## MEMORANDUM

**TO:** Jean Fraser, Planner  
**FROM:** David Senus, P.E. & Ashley Auger, E.I.T.  
**DATE:** April 18, 2013  
**RE:** 2282 Congress St. Multi-Use Development, Level III Final Site Plan Application

SHEET TITLE
GRADING AND DRAINAGE PLAN

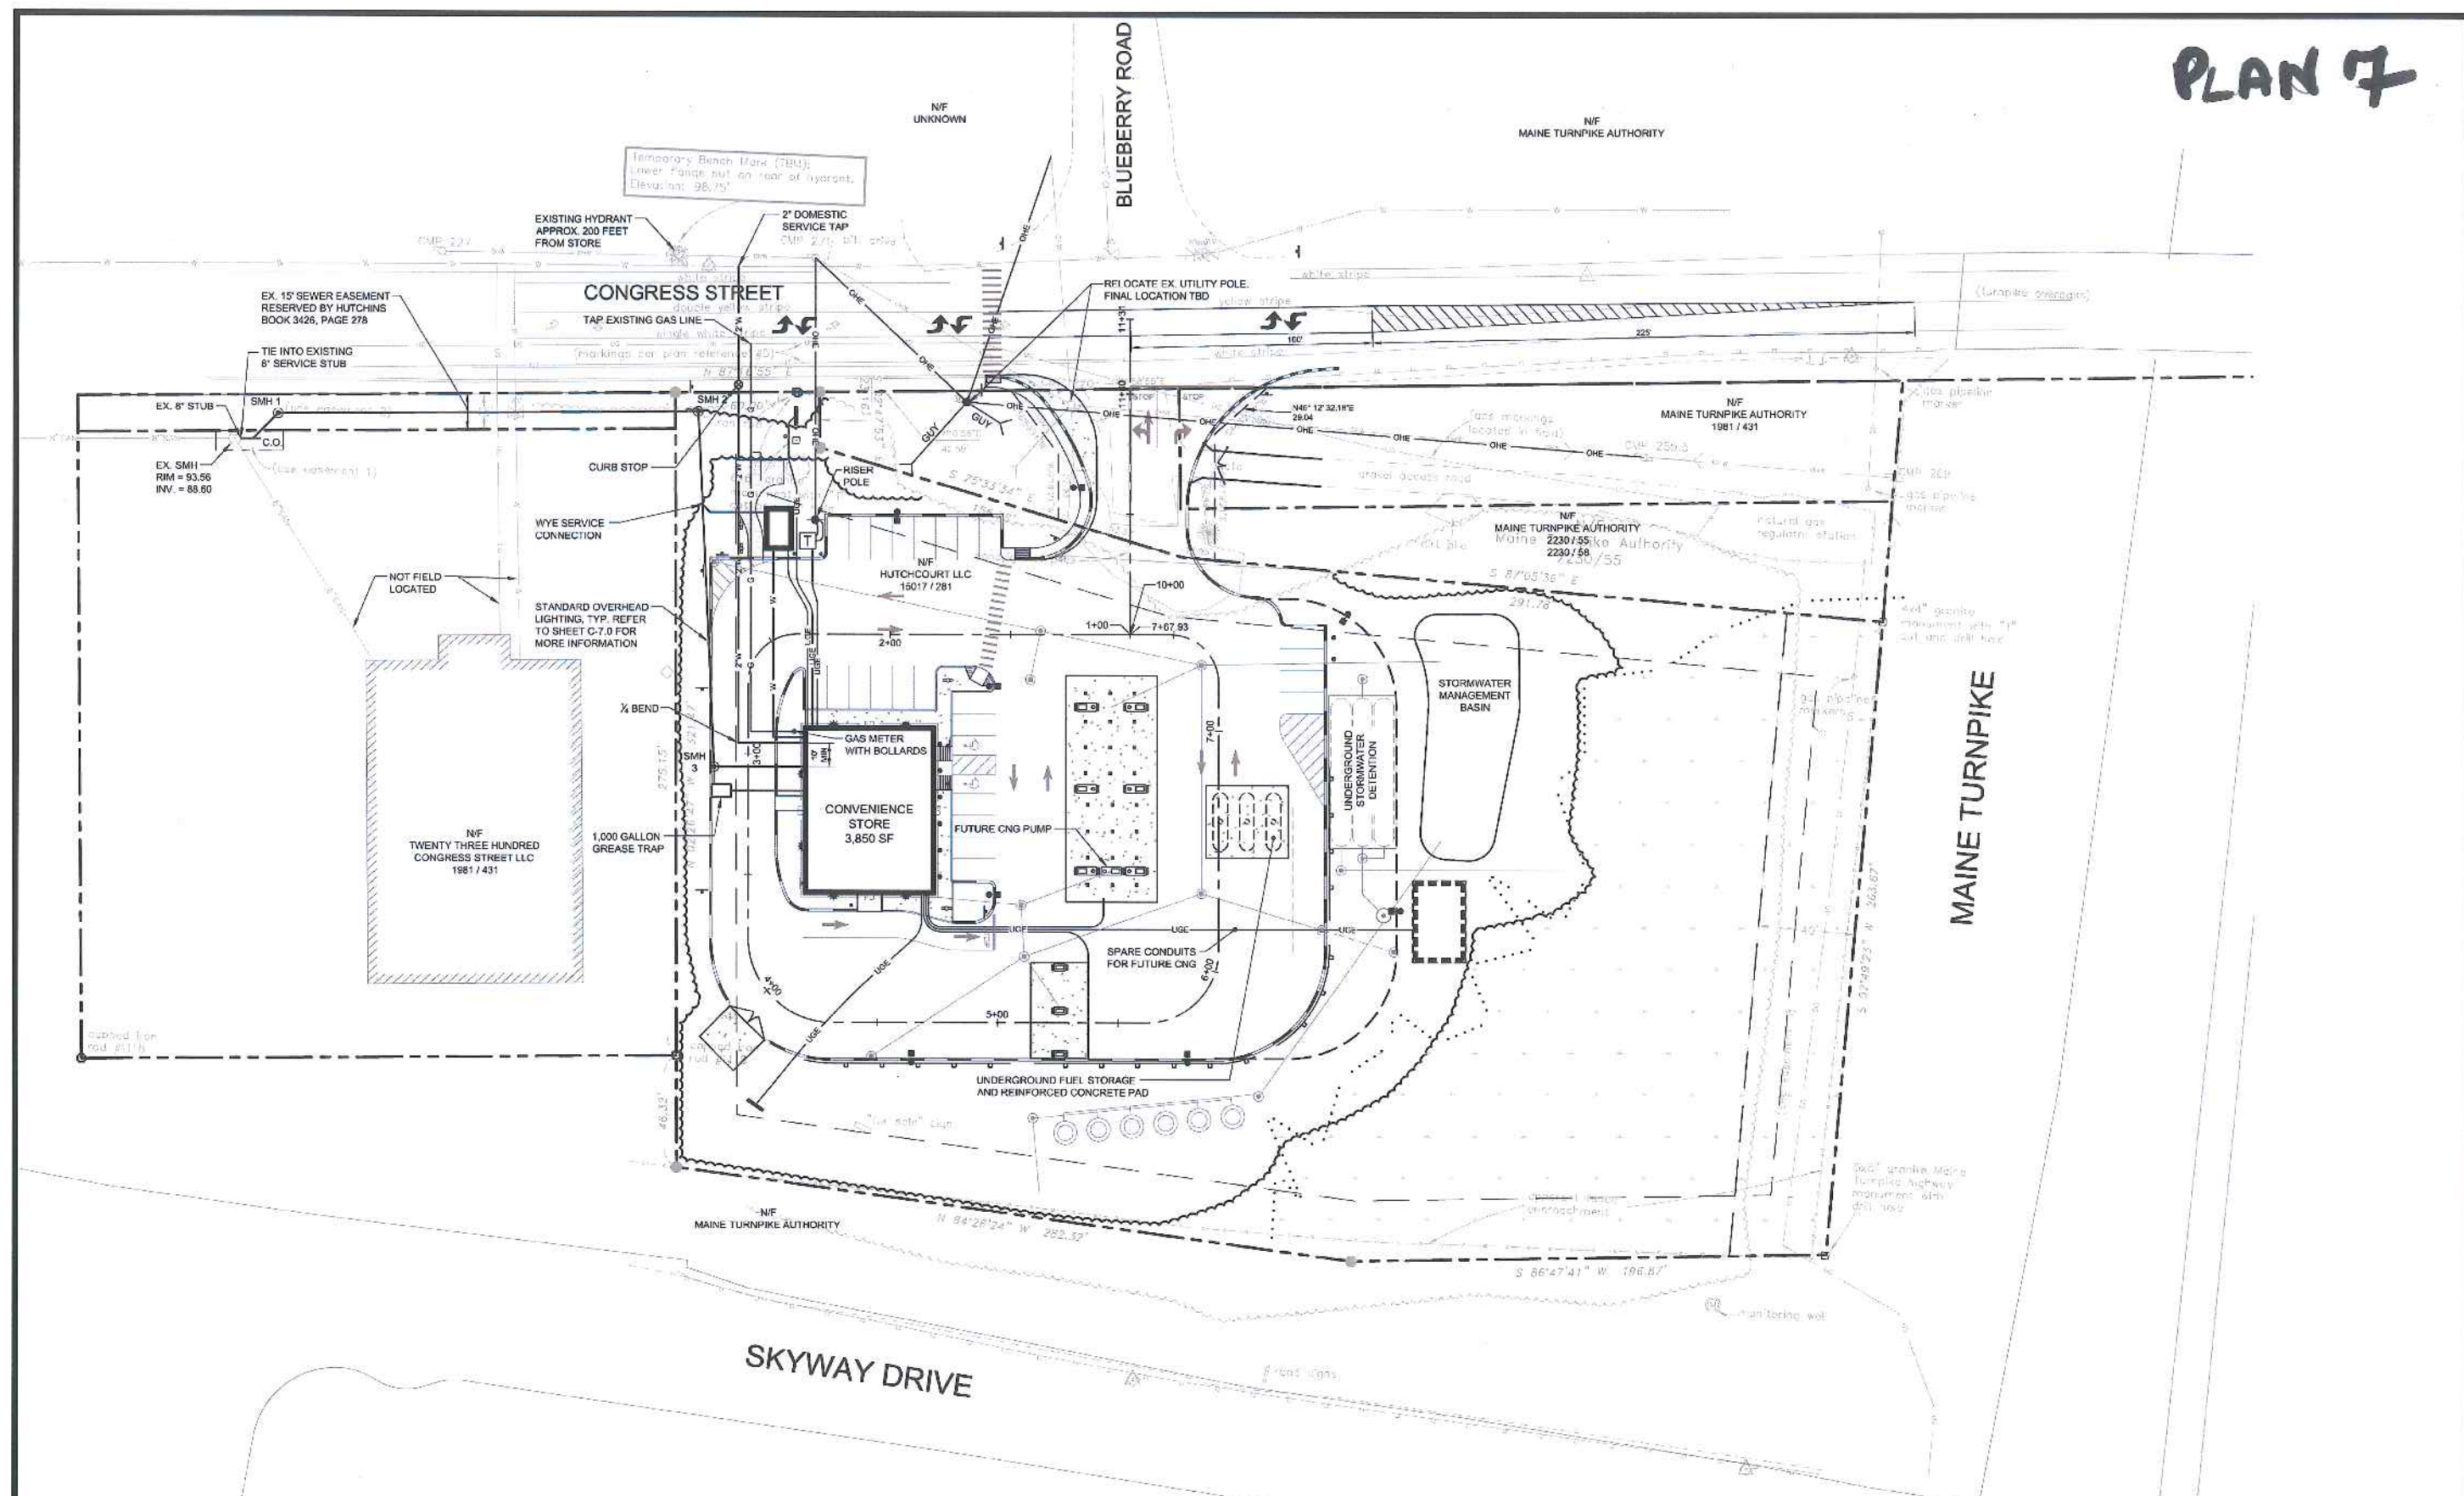
- 4) The plans should include proposed pipe invert elevations, pipe materials & sizes, and manhole/catch basin structure rim elevations.
- 5) Please provide clarification, potentially additional plan view notes/details, for the pipe configuration and weir system located within structure A3 and the header/discharge pipes associated with the StormTreat system.
